***Garvan St Vincent's Campus Cancer Centre,
Darlinghurst***

***MP 09_0011 MOD 1 – Modifications to
building alignment; northern façade signage
and ground floor tenancy use***

Director-General's
Environmental Assessment Report
Section 75W of the
Environmental Planning and Assessment Act 1979

November 2012

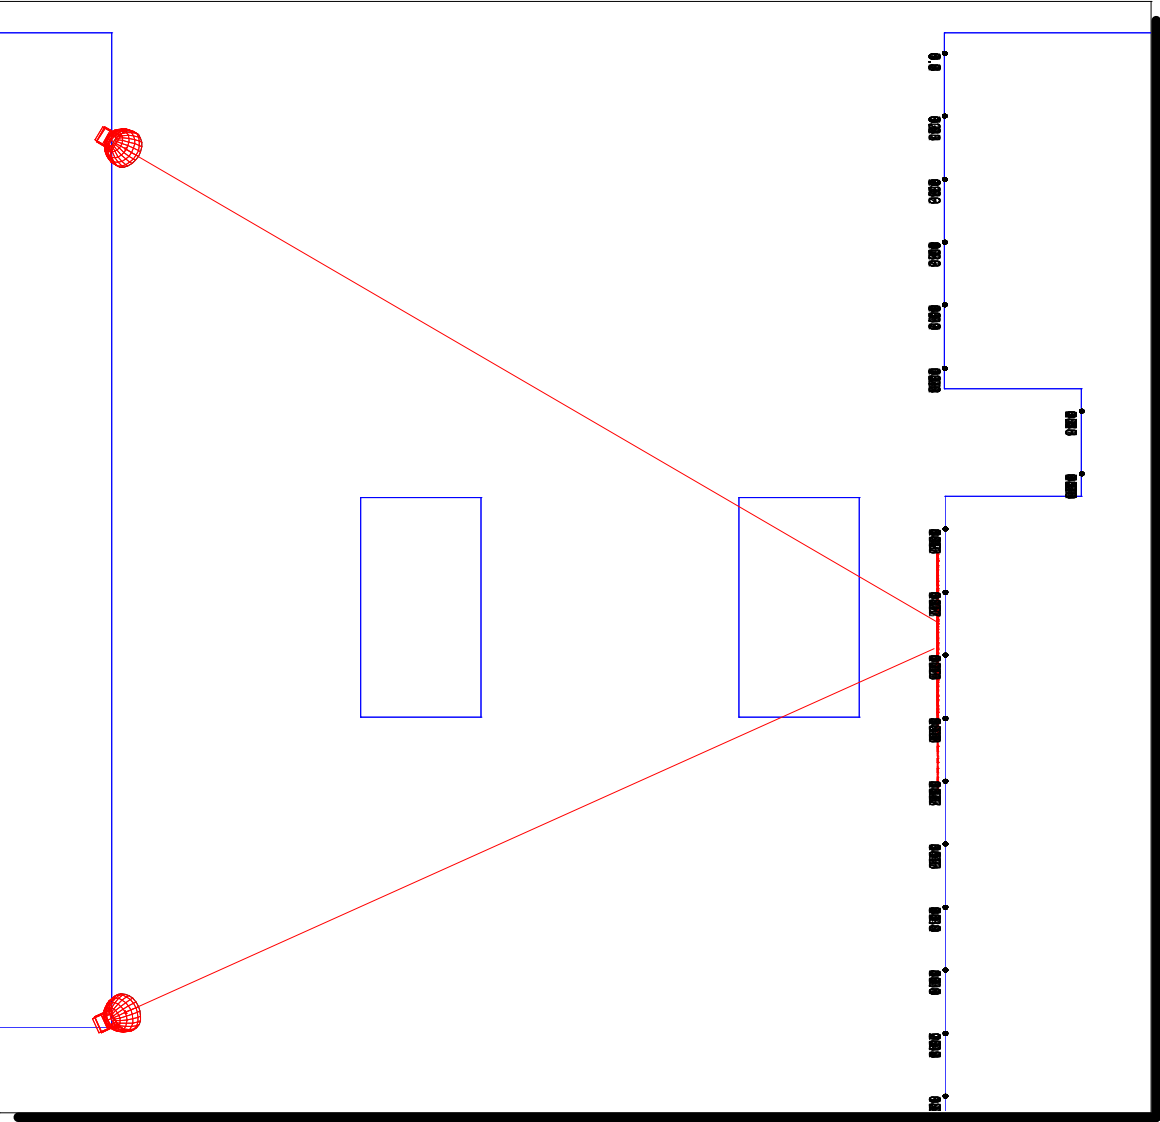
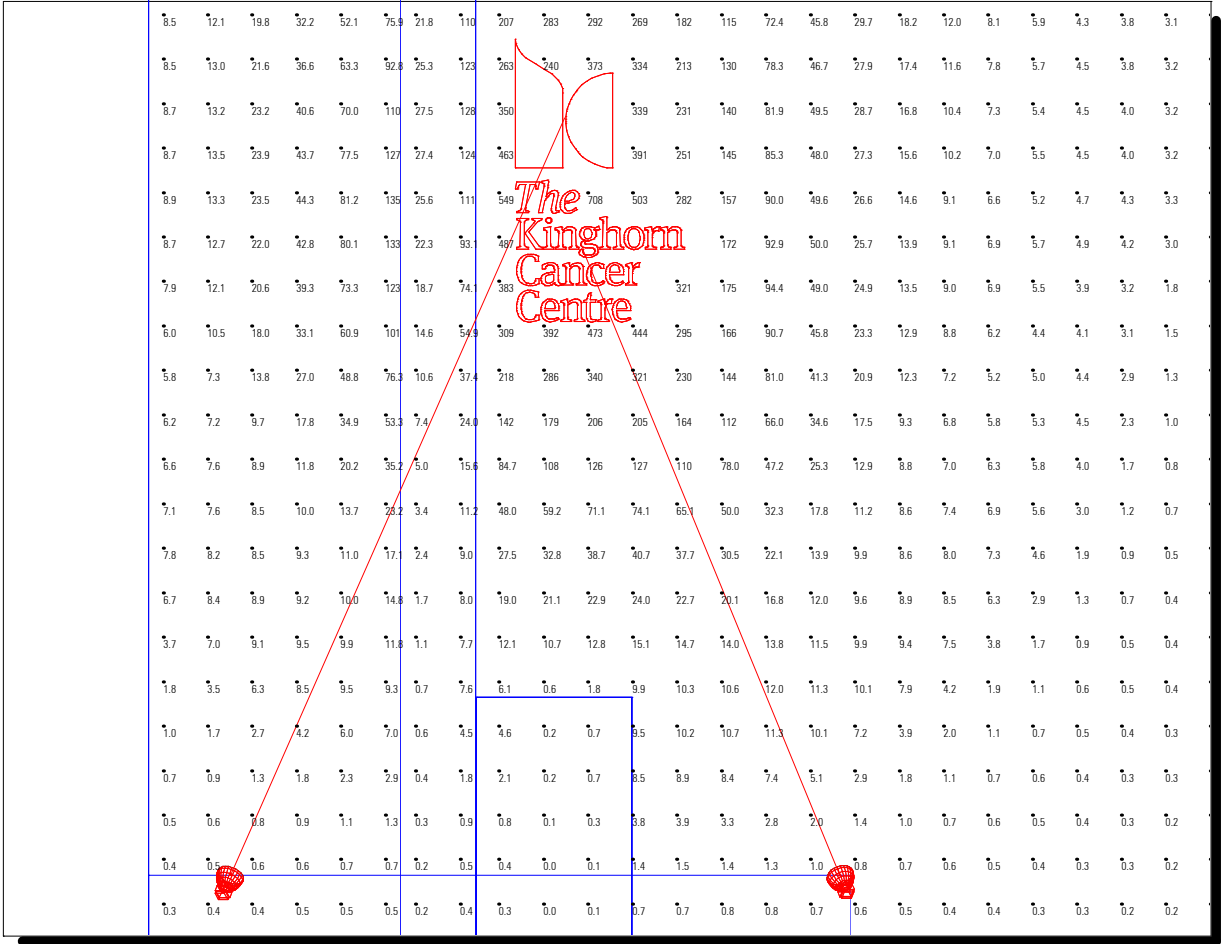
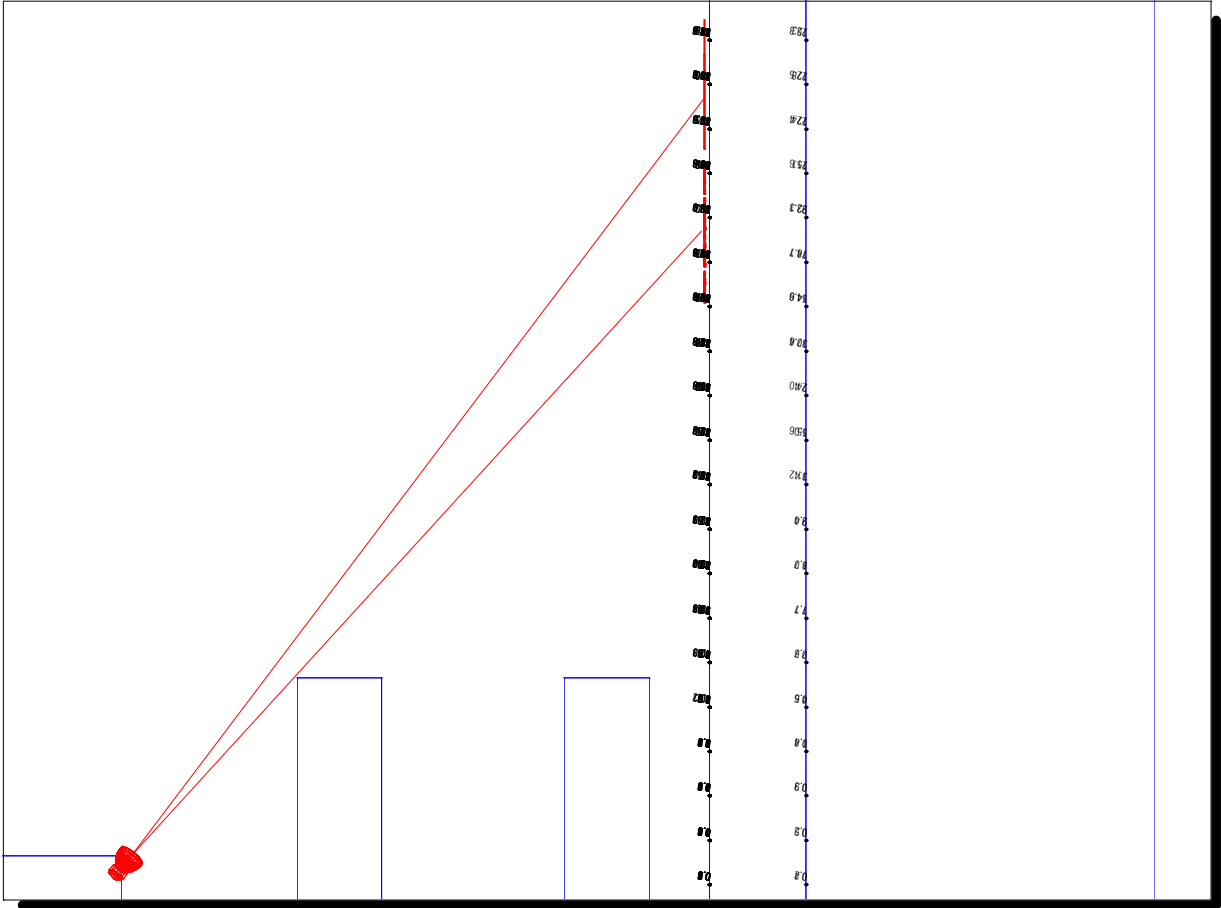
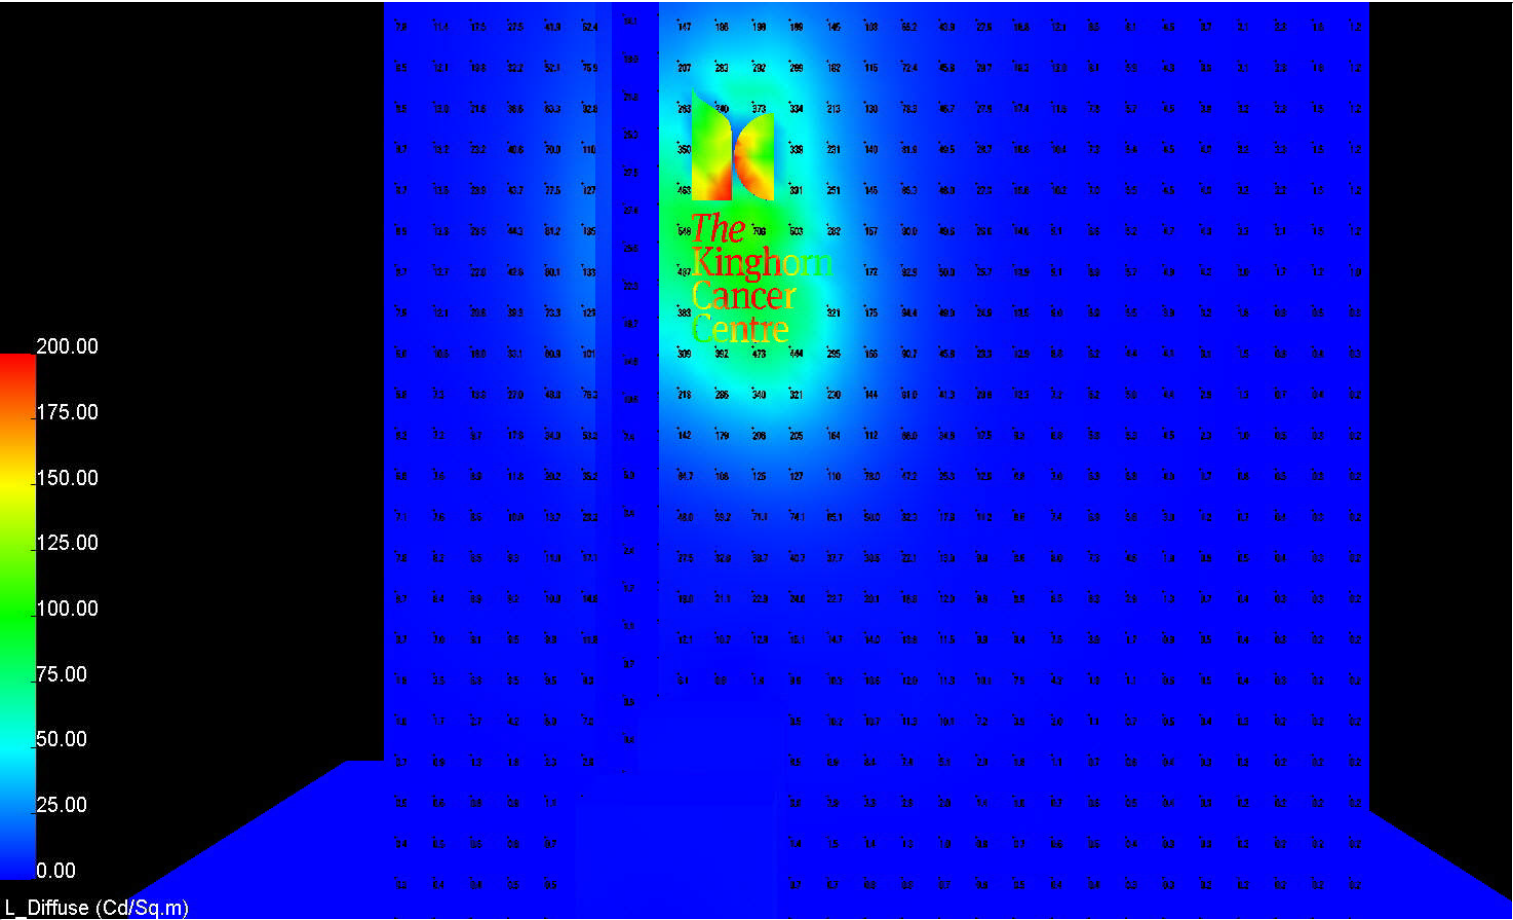
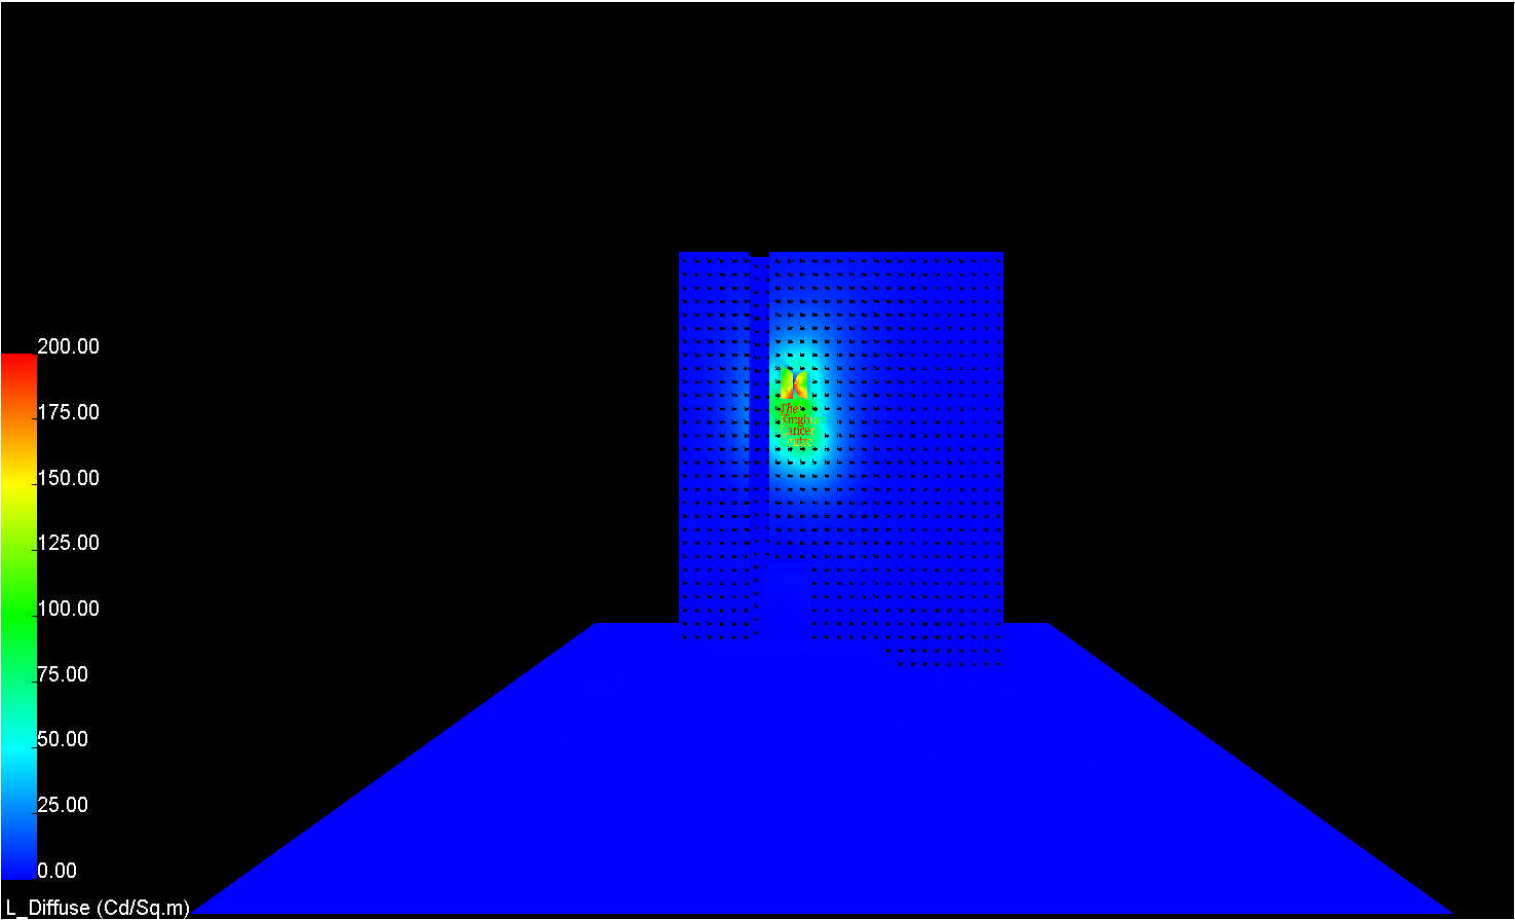
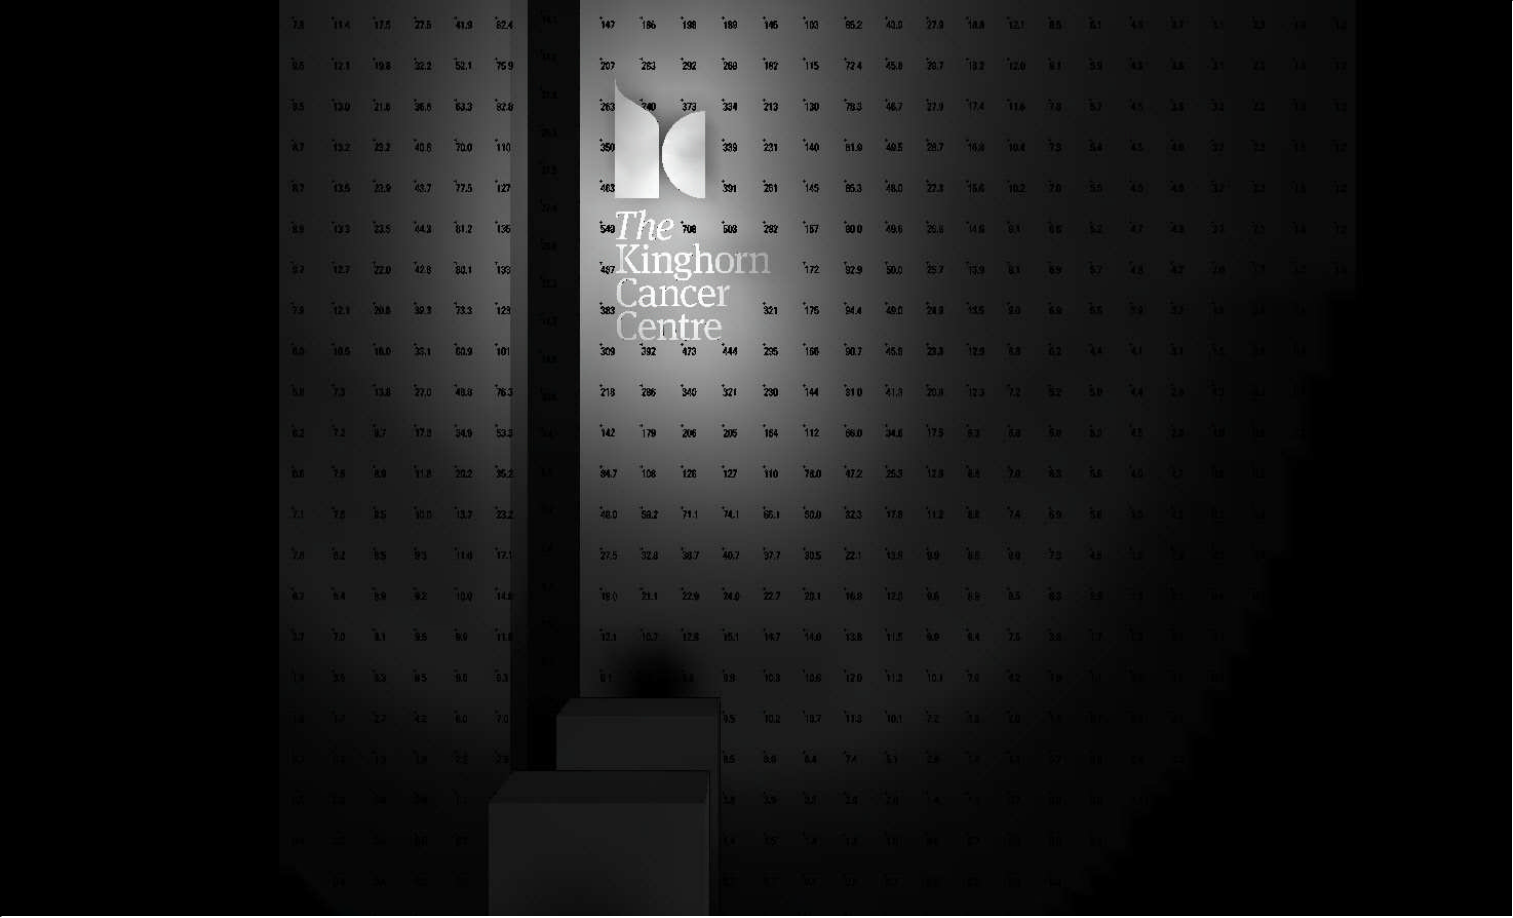
The proposal seeks to modify an existing approved sign by illuminating the 'Kinghorn Cancer Centre' logo on the Kinghorn Cancer Centre northern façade. The signage is to be illuminated at night by two 440 watt spot lights, which will shine from either side of the sign from level 6 below, as shown in **Figure 2**. The signage is to be constructed from steel plate with a matt finish to limit glare.

Council indicated that any signage should not be too bright or flash and should not result in light spill beyond the signage. The proponent indicated that a light analysis has been undertaken showing light spillage to be at an acceptable level, particularly as the light is angled away from residential development.

On this basis, the Department considers that the proposed signage modification is acceptable given that:

- the signage will be orientated away from residential developments;
- the signage will be constructed from steel plate logo with matt finish to limit glare; and
- the signage is consistent with the objectives of AS4282-1997 and State Environmental Planning Policy No. 64 – Advertising and Signage.
